Subject: Planning application BR/75/20/HH

PROPOSED PLANS AND ELEVATIONS

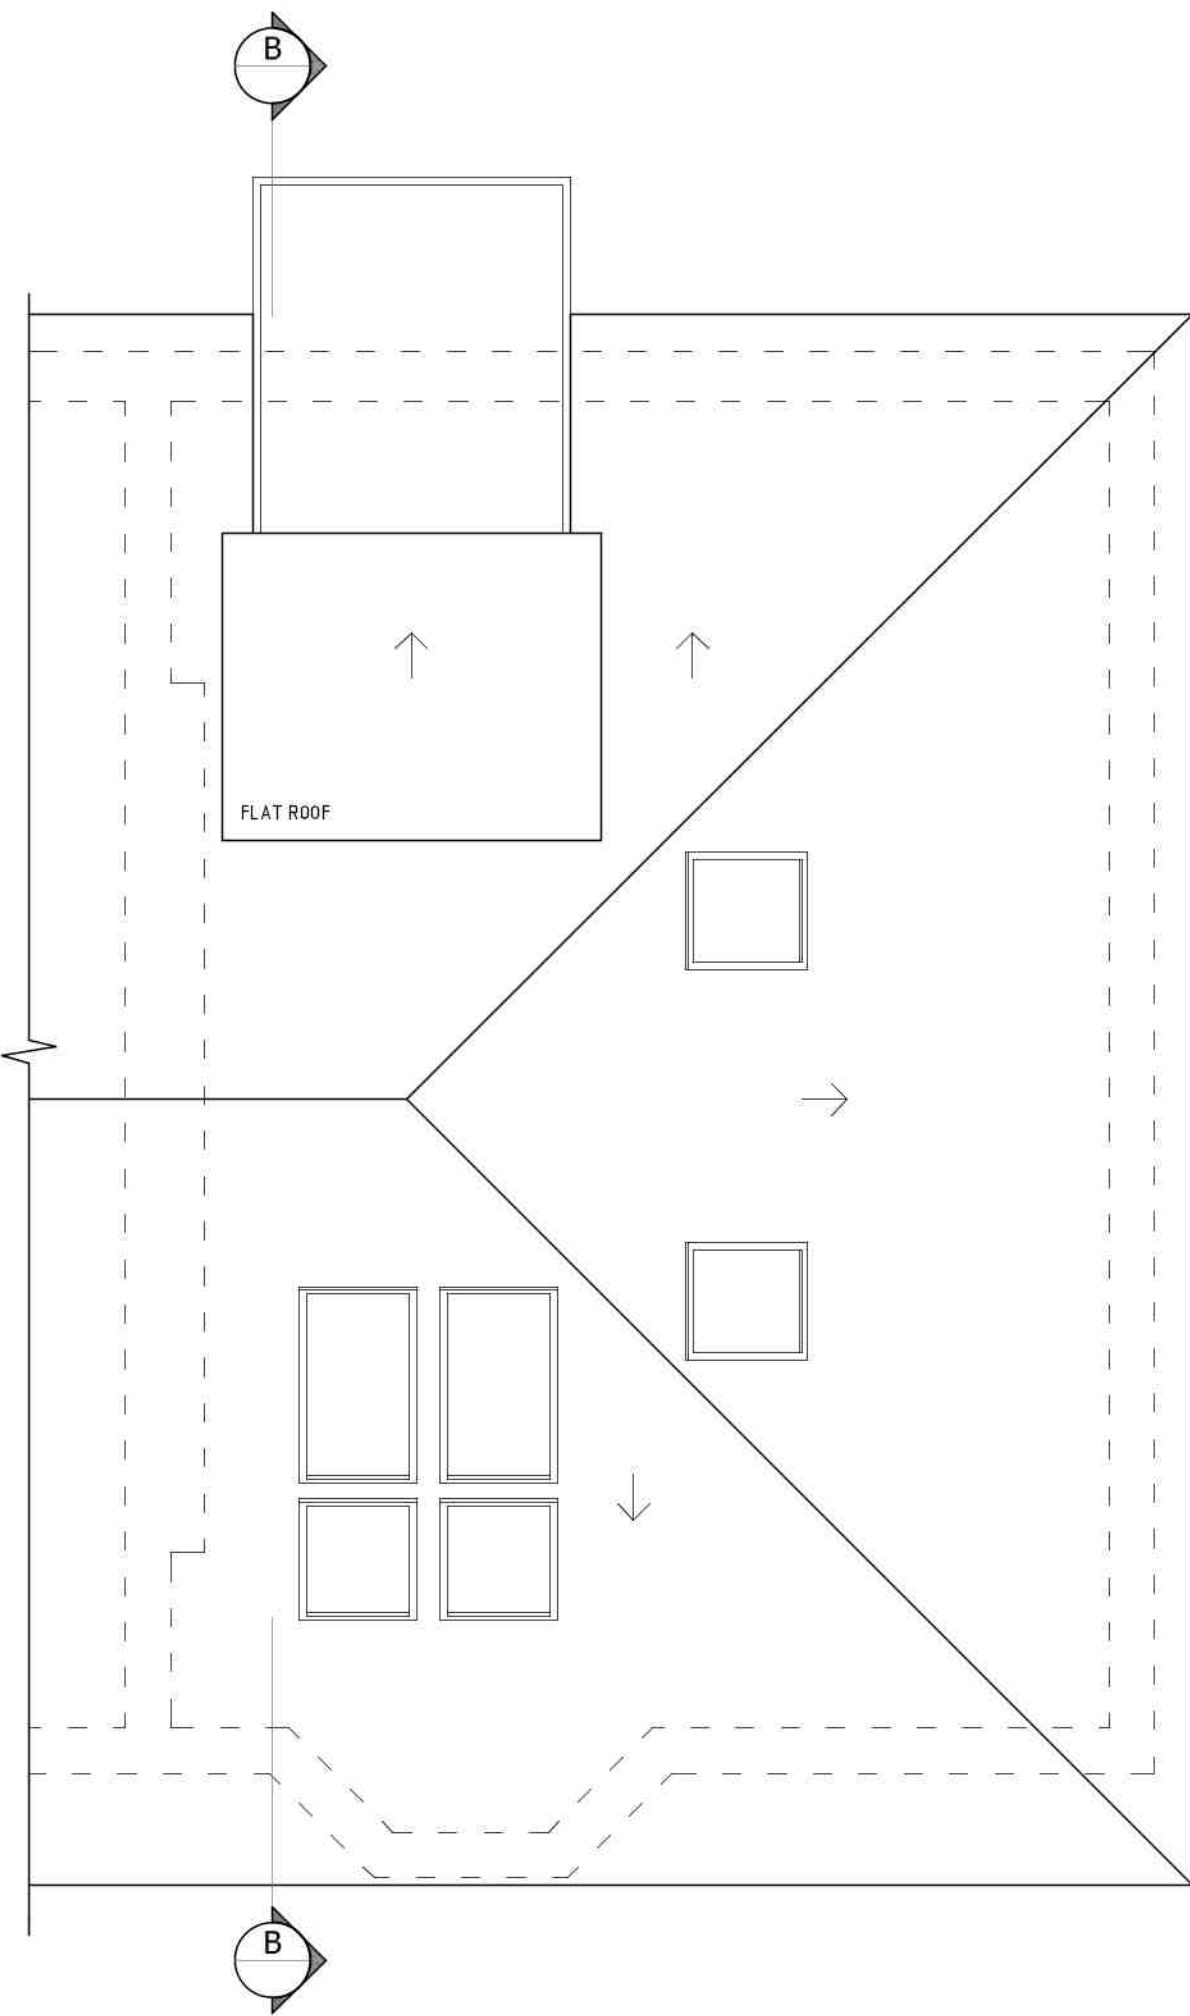
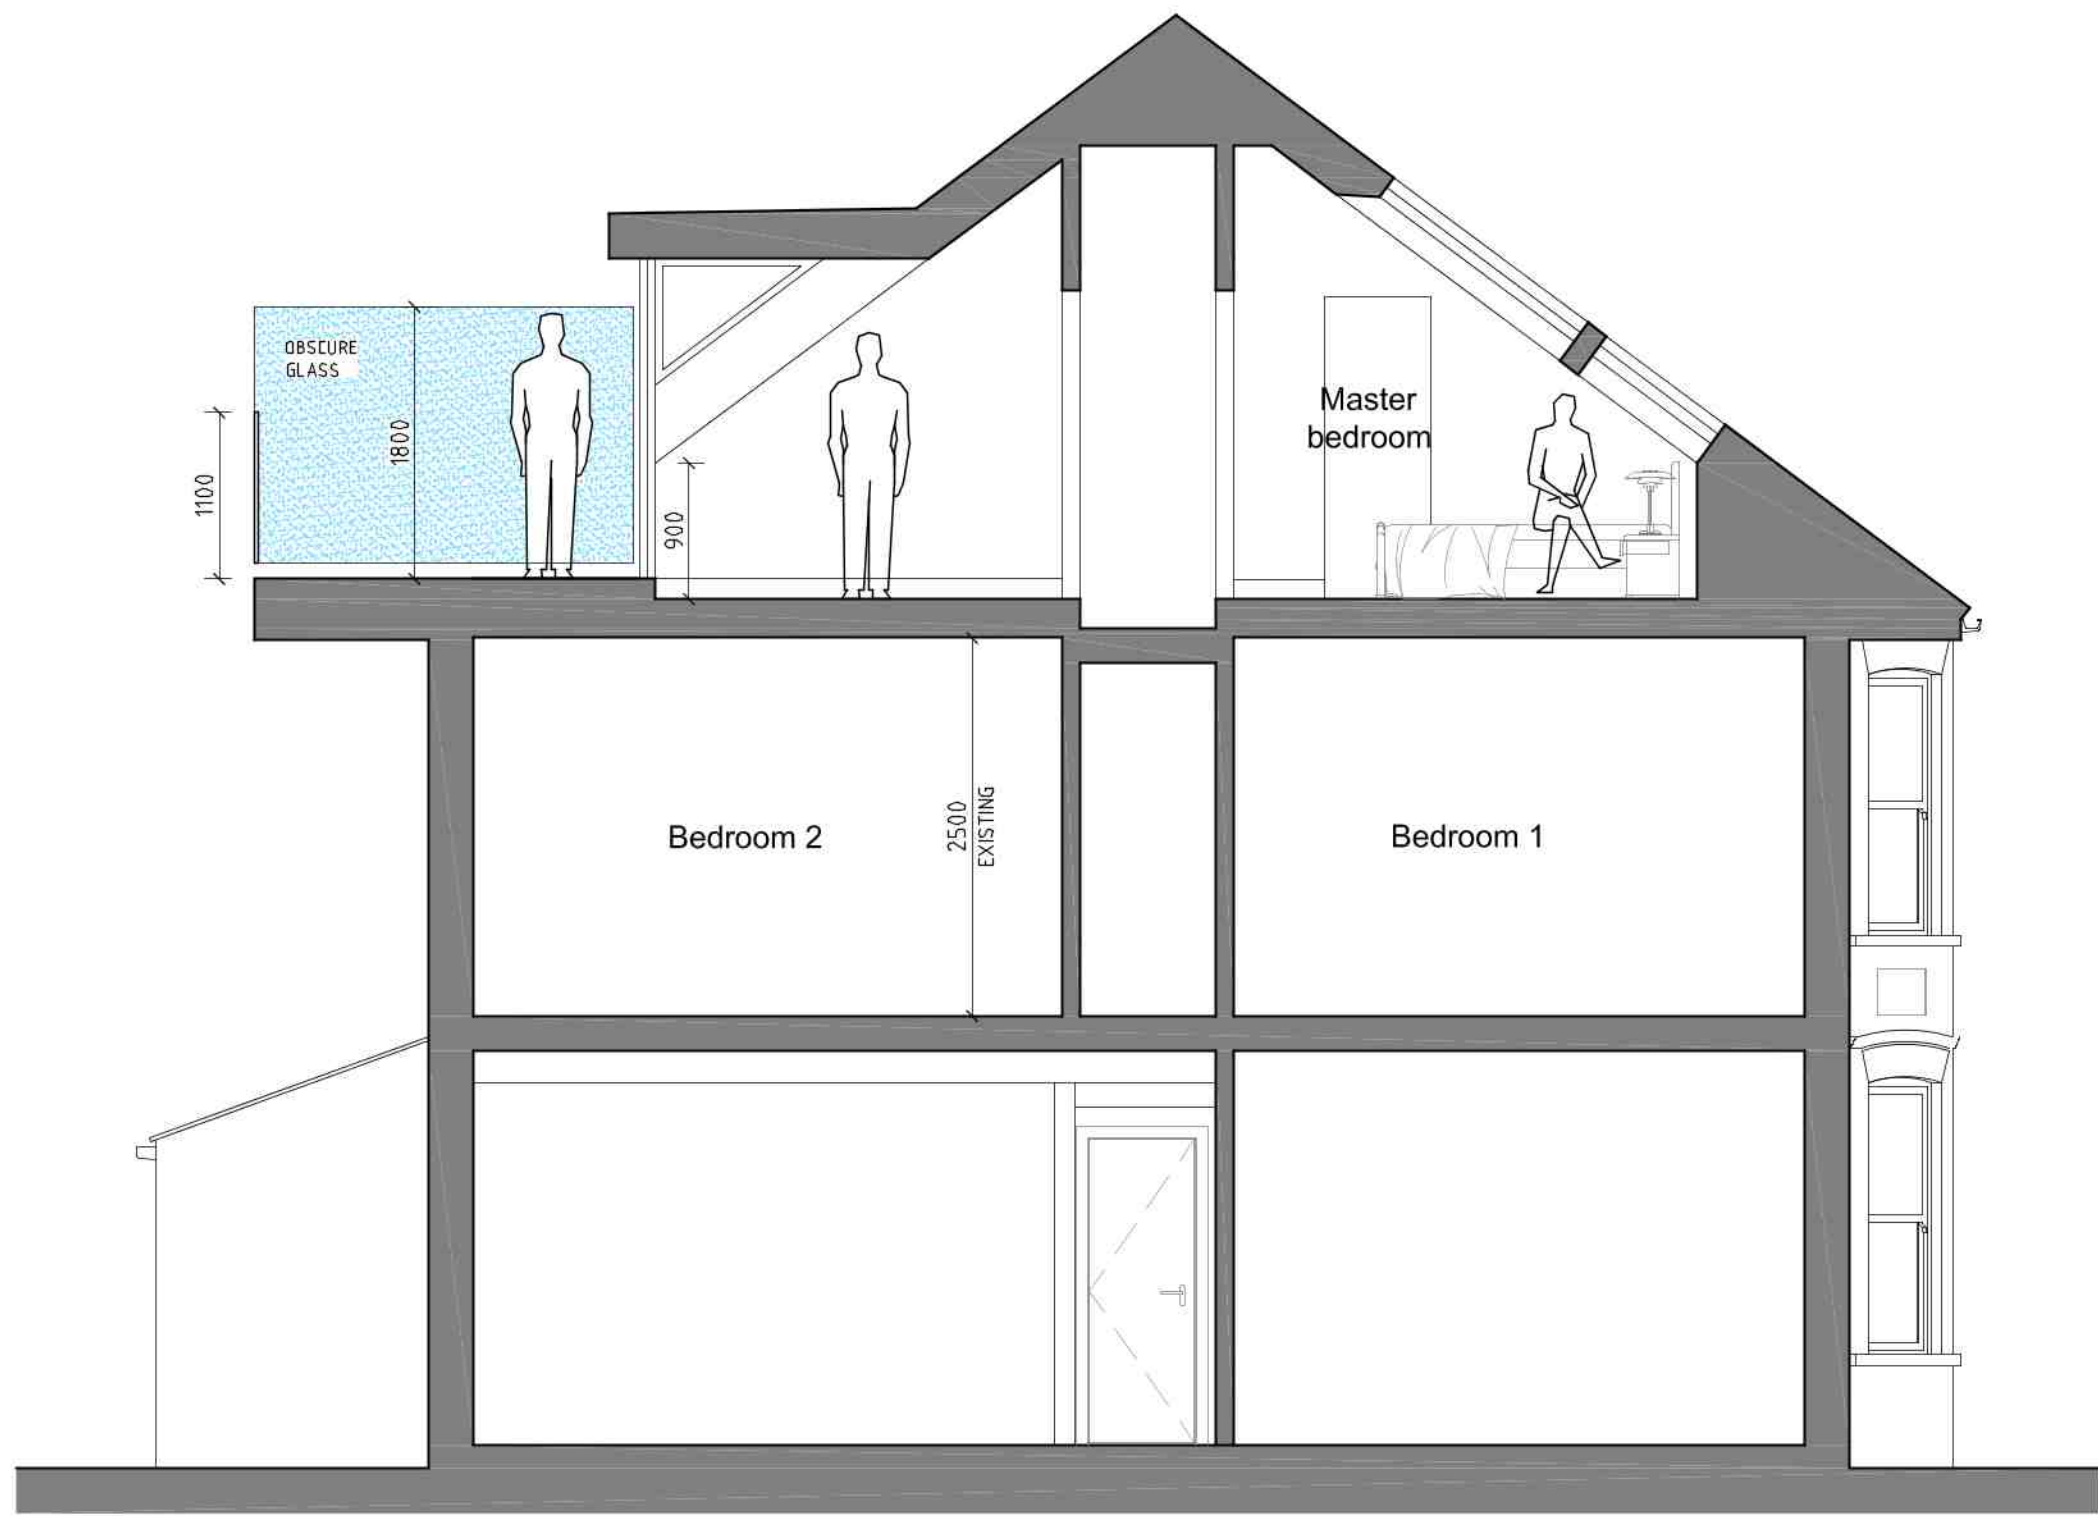
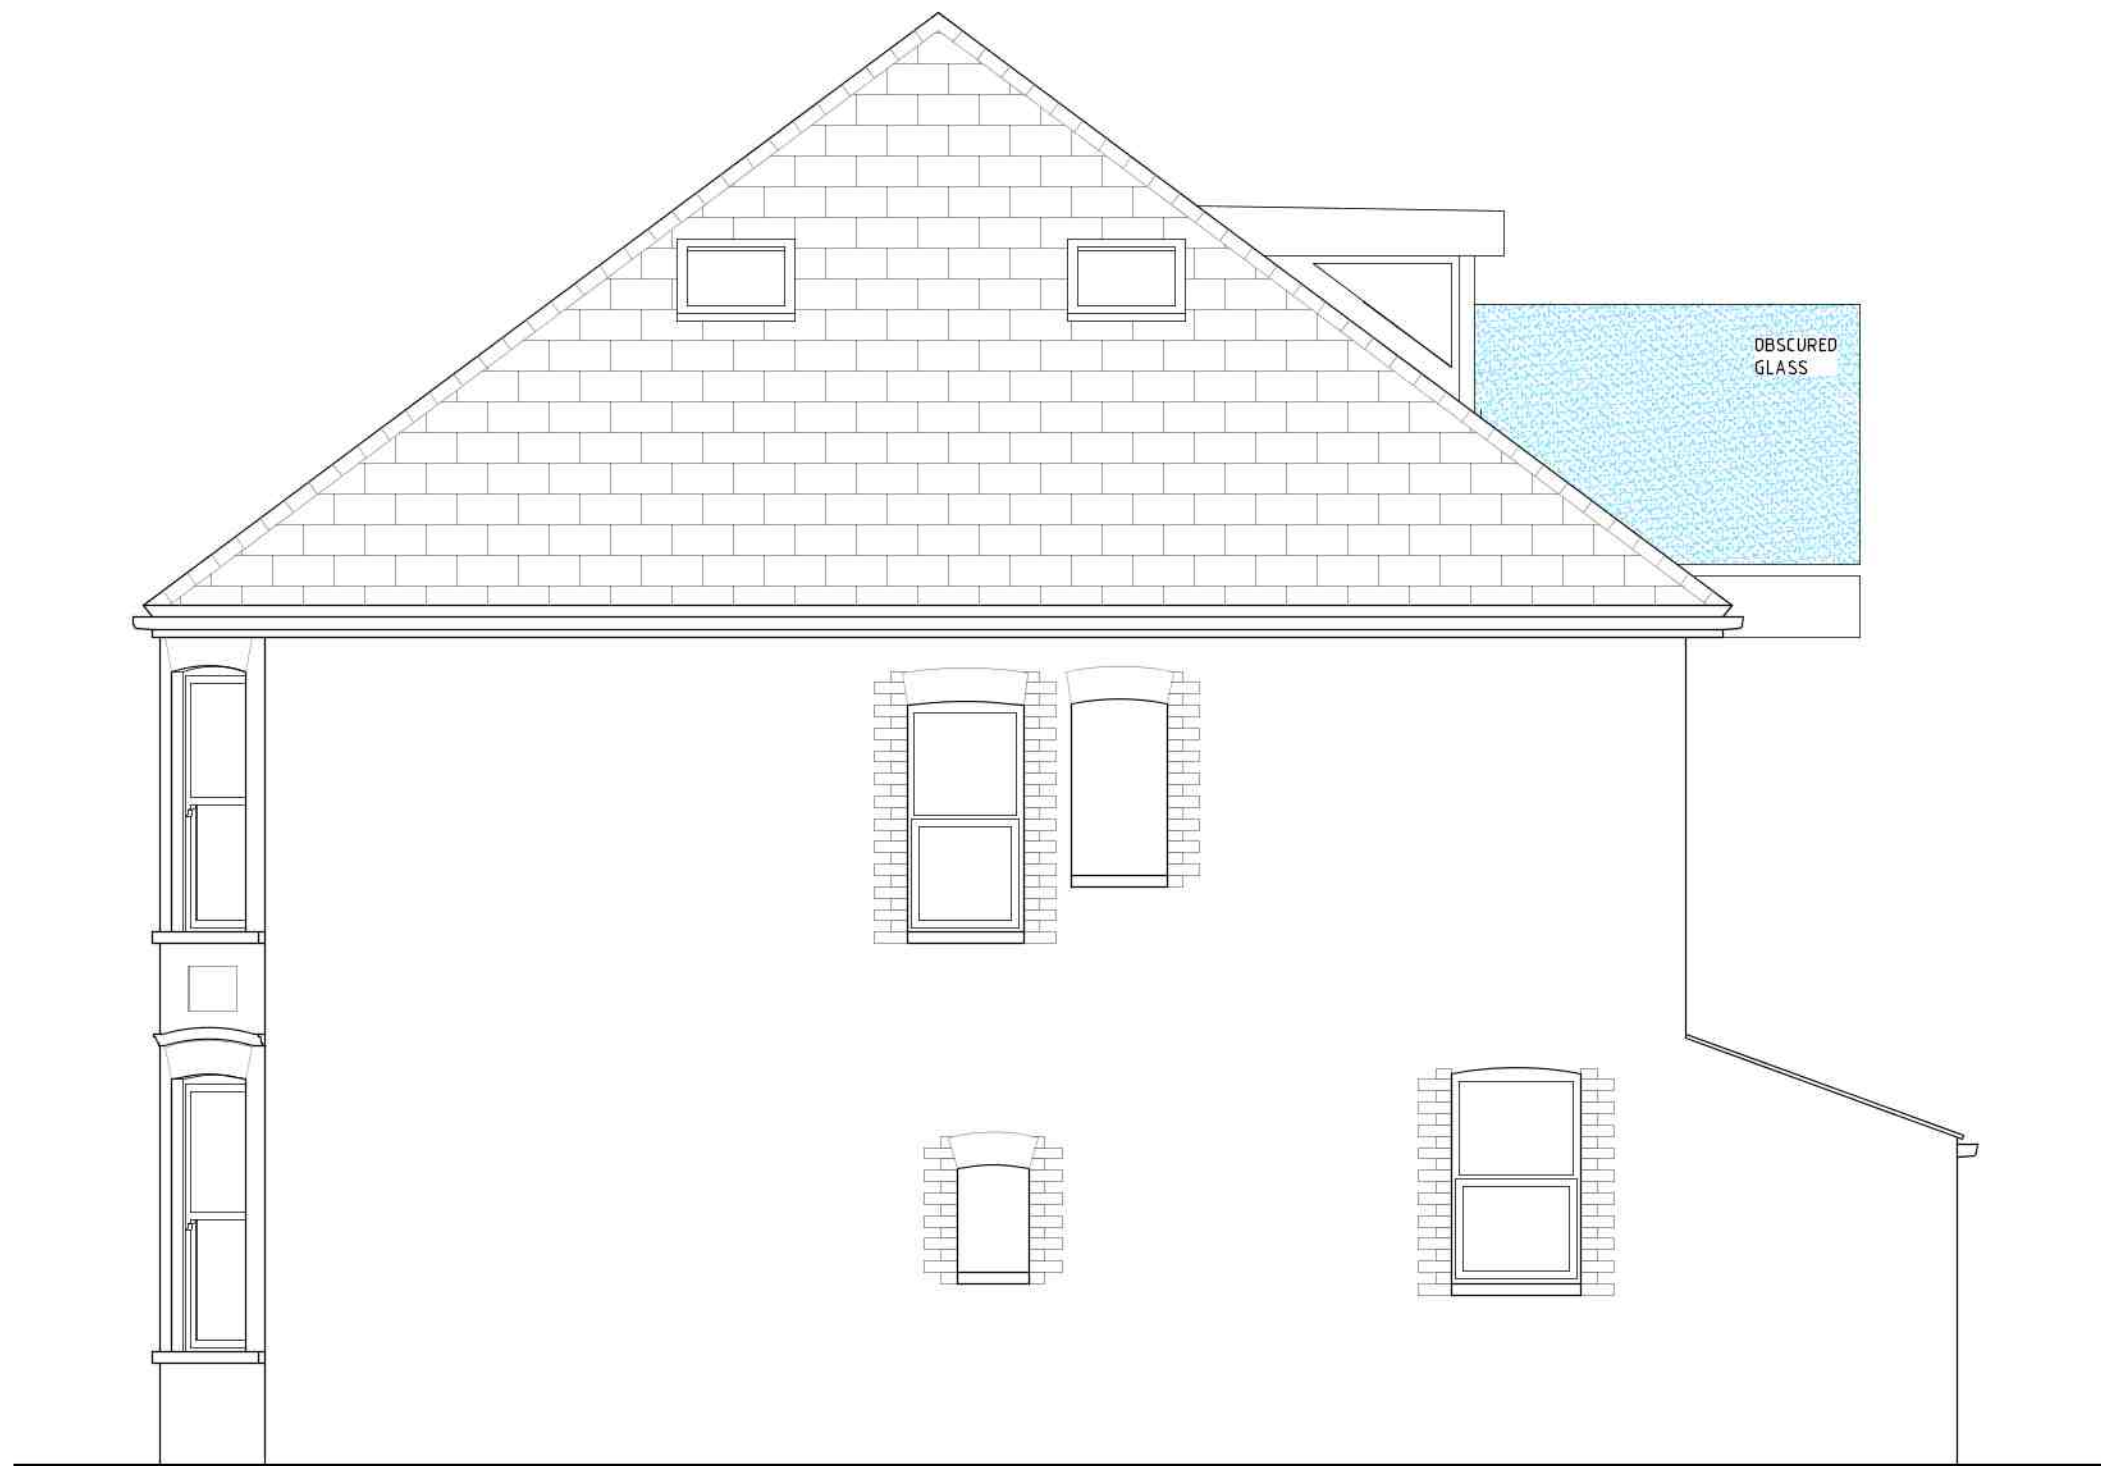
With regard to the above application, I am not against any application persay, which can be made to fit in with good architecture. But I feel it has got some unsuitable aspects. This area is an 'enclave' with Spencer st which are mostly 2-storey Edwardian/mid war with not particularly large gdns. Particularly unsuitable is the large glass 'box' which will stick out of the slate roof PAST the roof line. This is both visually intrusive, and will look over the surrounding properties & gardens, and make it as good as a 3 storey building.
